City of Albuquerque Stormwater Construction Site Inspection Report

Project Name:	Campbell Coumpound				
Location:	Campbell & KaylaLn NW - 2240 Campbell Rd				
Site Contact Name & Agency	T Scott Ashcraft	ESC File No.	G13E032		
	Adam Romero	NPDES Id. No.	NMR1001ZW		
Inspection Date:	07/01/19	Start/End Time:	0930/1000hrs		
CoA Stormwater Inspector:	Timothy E. Sims				
Construction Phase:	Home Construction				
	<input checked="" type="checkbox"/> Regular	<input type="checkbox"/> Storm Event	<input type="checkbox"/> Post Storm Event >0.25"	<input type="checkbox"/> 311/Complaint	<input type="checkbox"/> Follow Up

EROSION AND SEDIMENT CONTROL PLAN

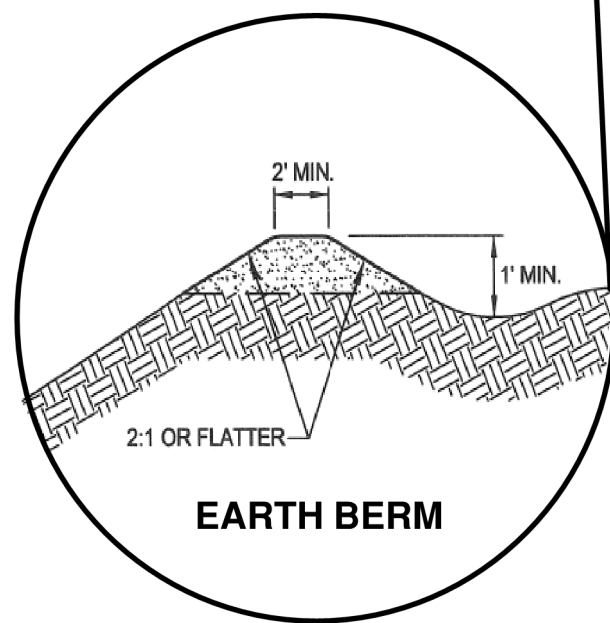
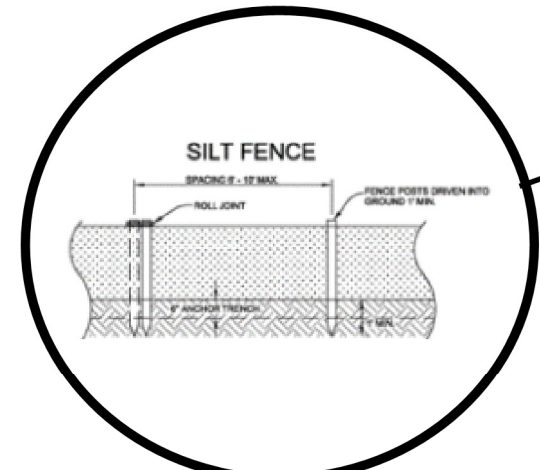
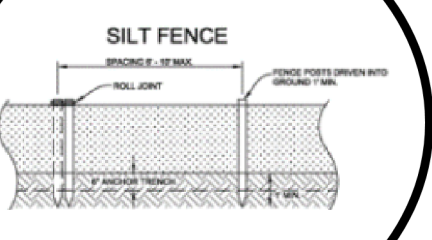
Item Number	Deficiency/ Corrective Action		
1	Washouts on various lots please clean and have trade utilize provided concrete washout facility.		
2	Please provide the latest SWPPP self-inspection report.		
2.1	Discharge off site? (Y/N)	No	
4	Self Inspection Reports	reports	Latest report Date: 5/10/2019
